From: Lewis, Trevor [mailto:Trevor.Lewis@lancashire.gov.uk]
Sent: 18 February 2013 11:08
To: Colin Sharpe
Subject: 3/2013/0004 Four dwellings, Nethertown Close, Whalley

I would ask for three on-site parking spaces for each of these four bedroom dwellings. Plot four is provided with 4 parking spaces which is acceptable. According to the 'proposed housing schedule' on drawing WHA/01 Dwg 04A, Plots 1 to 3 are provided with 2 on-site parking spaces, and this is insufficient parking. It is not clear from the layout drawing, where these parking spaces are located, and I would ask for clarification on this. Insufficient on-site parking for this development will result in inappropriate parking on Nethertown Close and Mitton Road which will adversely affect highway safety.

| PROPOSED SITE PLAN                                                                              |                   |  |  |
|-------------------------------------------------------------------------------------------------|-------------------|--|--|
| Project No: WHA/01 Dwg 04A                                                                      | Drawn: NYB        |  |  |

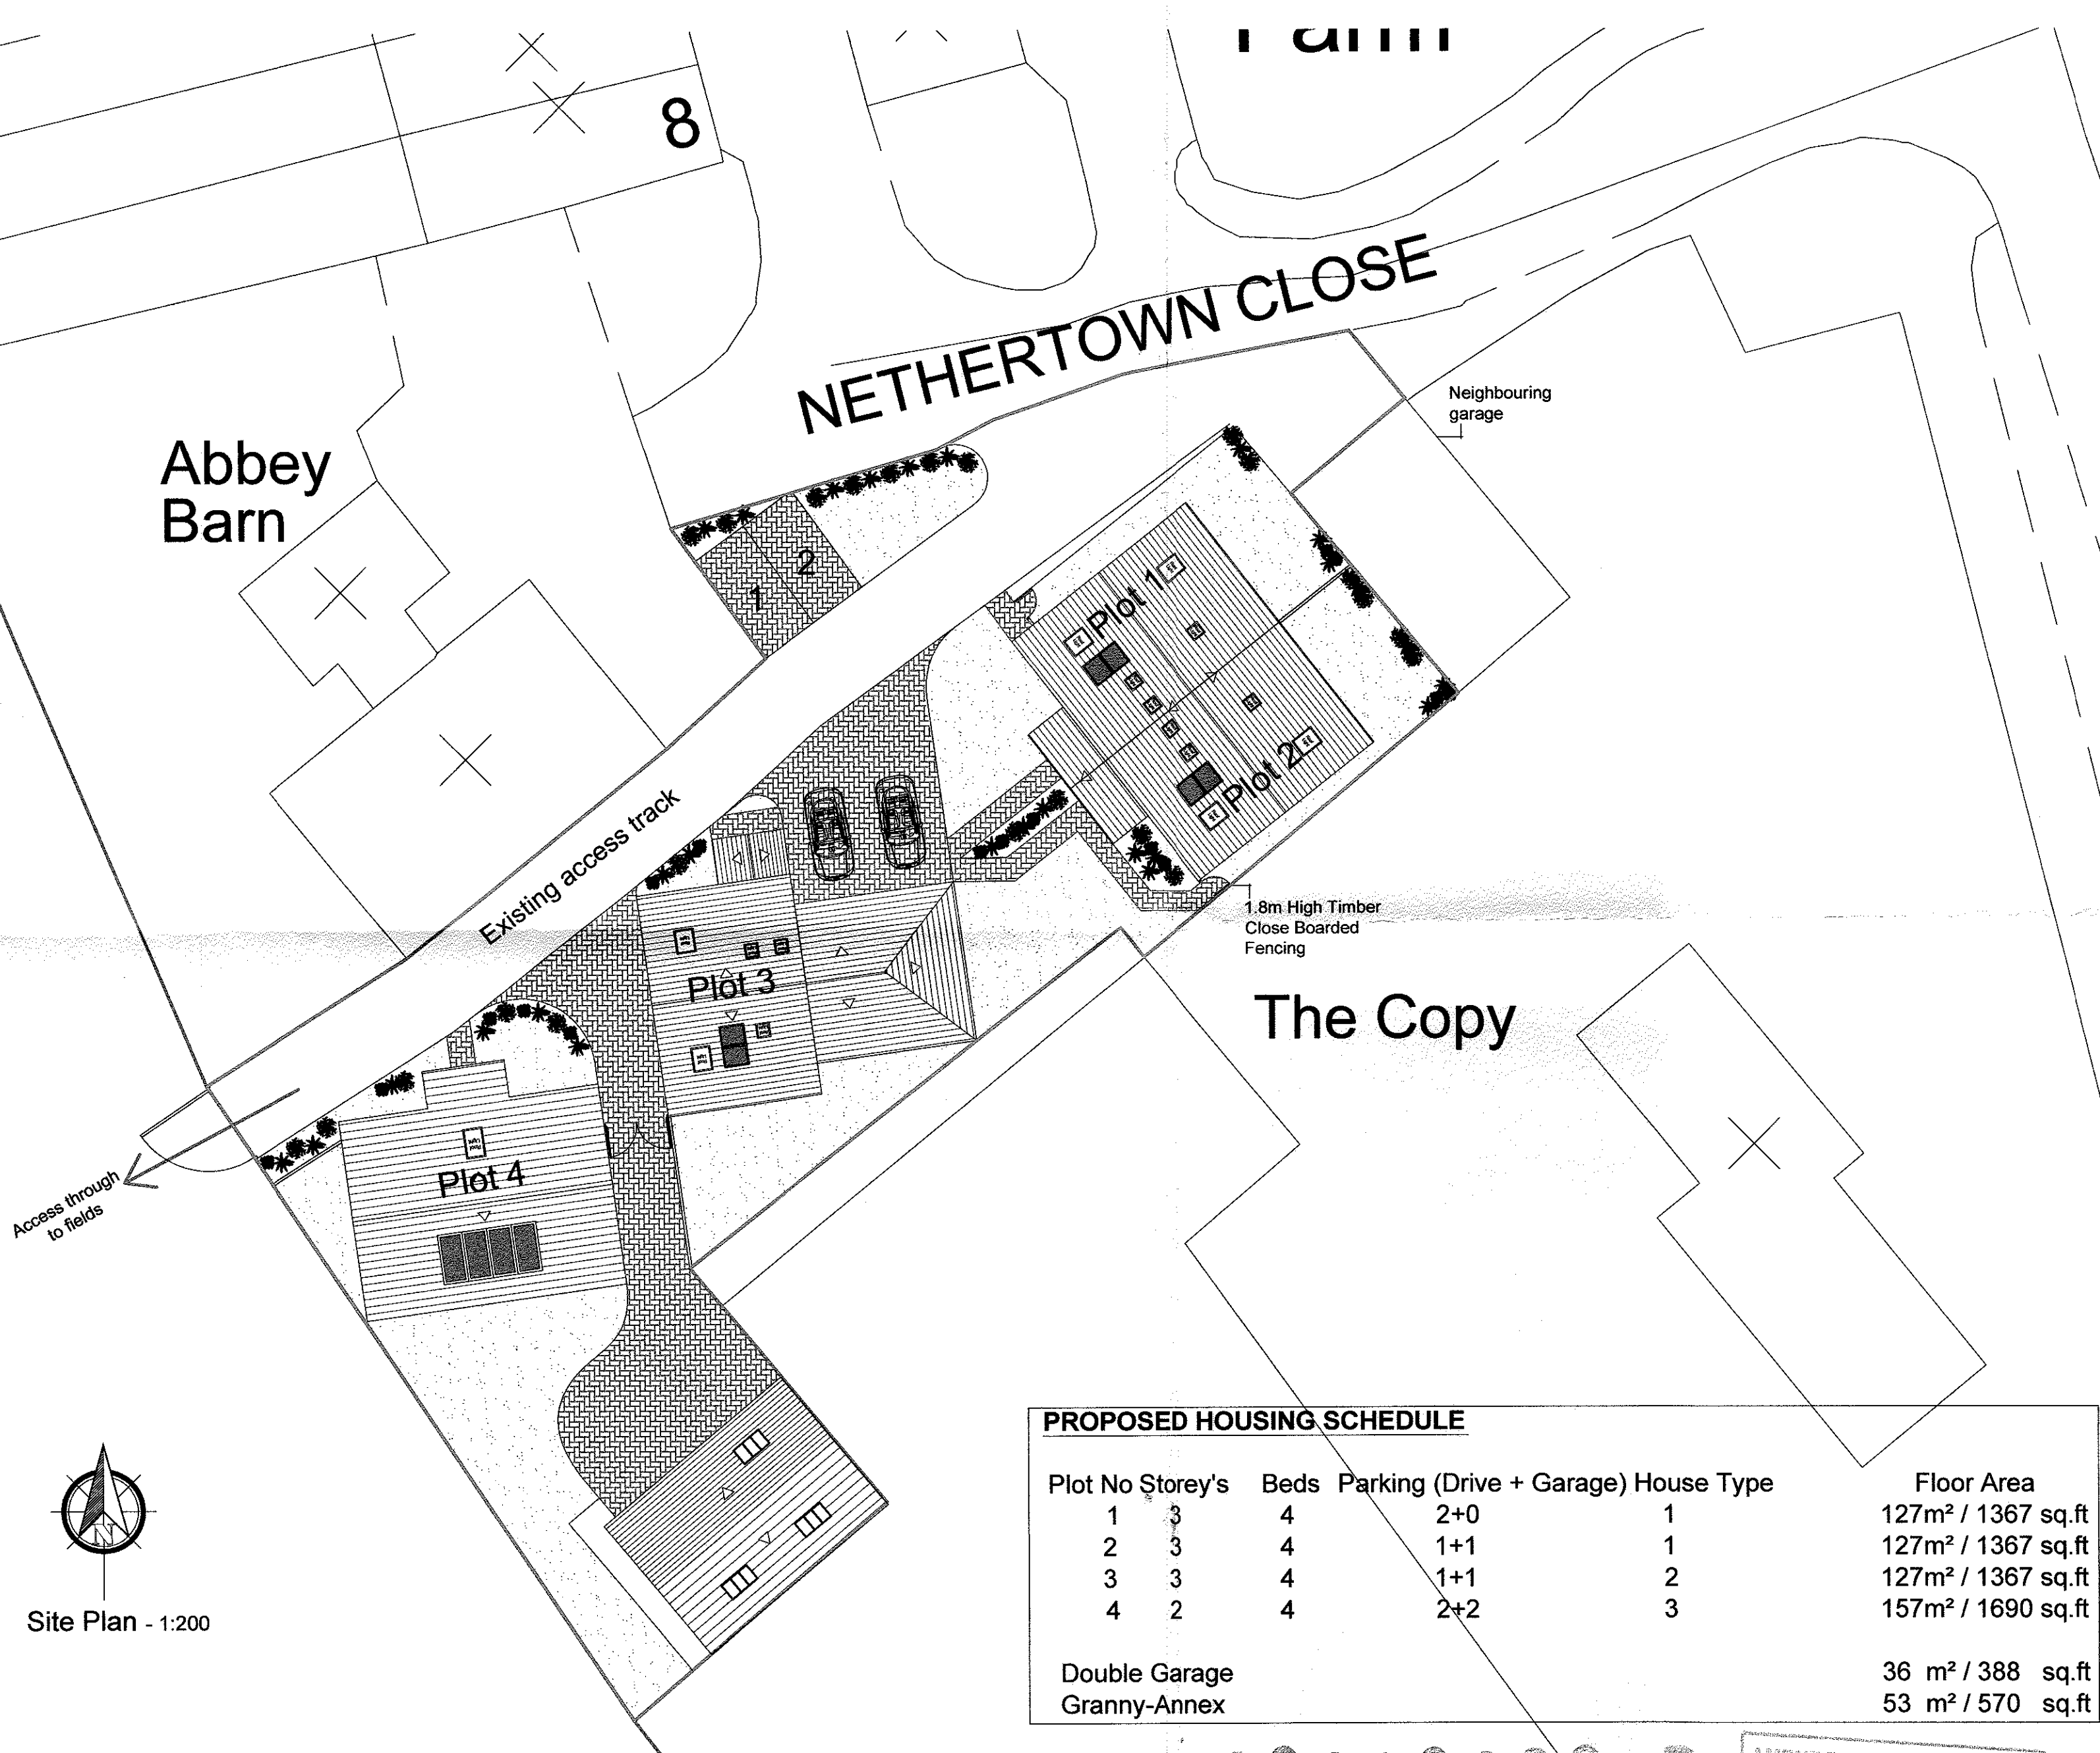
Parking spaces numbered 1 and 2, would appear to have insufficient space to reverse and turn within the access track, and this appears to be impractical as drawn.

I would ask for works to be carried out at the junction of the access track and Nethertown Close to rationalise this access. The access track should be a minimum of 4.5m wide, for a minimum distance of 6m from the edge of the Nethertown Close carriageway. This work should include some provision for pedestrians at this junction.

The existing access track should be surfaced, at least as far as the drive way to plot 4 from the junction with Nethertown Close.
